Consultation Response from KC, Trees
2025/92135 2, Hollybank Avenue, Upper Batley, Batley, WF17 0AQ
Erection of single storey rear extension, rear dormer, first floor balcony on front elevation enclosed with feature gable windows.
Date Responded: 20/01/2026 Responding Officer: Hazel Irving Responding Ref: 23/77/a29

Proposed Ground Floor  
1 : 100

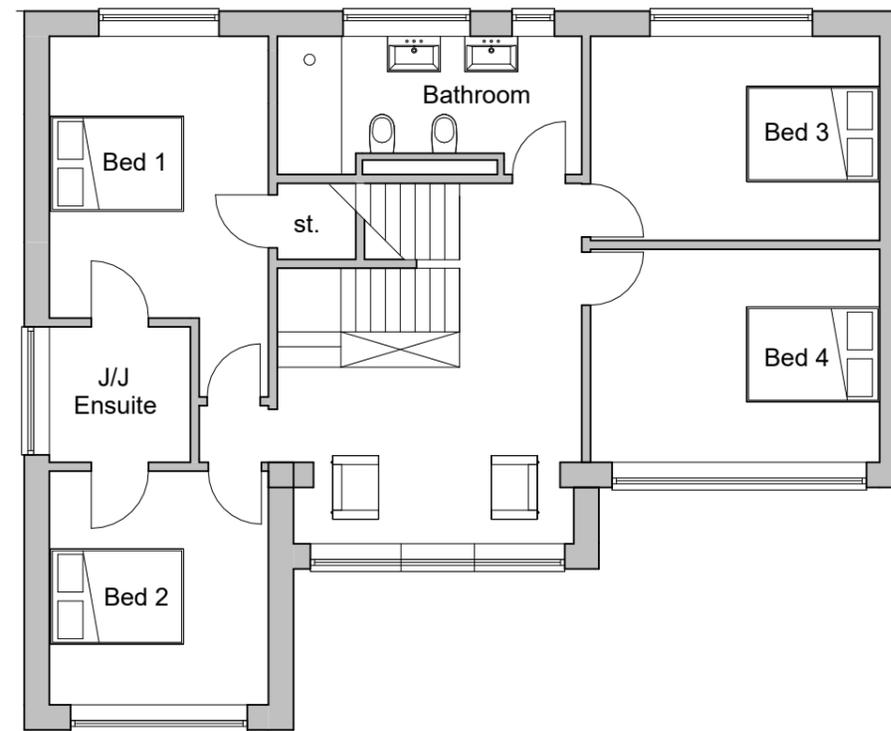
It is understood the application is for permission to construct a significant rear extension, which would fill the available space within the rear garden and threaten the protected trees on the Eastern boundary.

The extension is proposed to significantly encroach on root protection areas of protected trees, and the resultant building would be beneath the canopy line. These proposals are unacceptable from an arboricultural perspective as they would endanger the health of these protected trees, which would constitute a loss of ecological, environmental and amenity value to the surrounding area.

There is an objection from an arboricultural perspective. The proposal conflicts with the NPPF and adopted Kirklees local plan policy 33 and 24 (i).
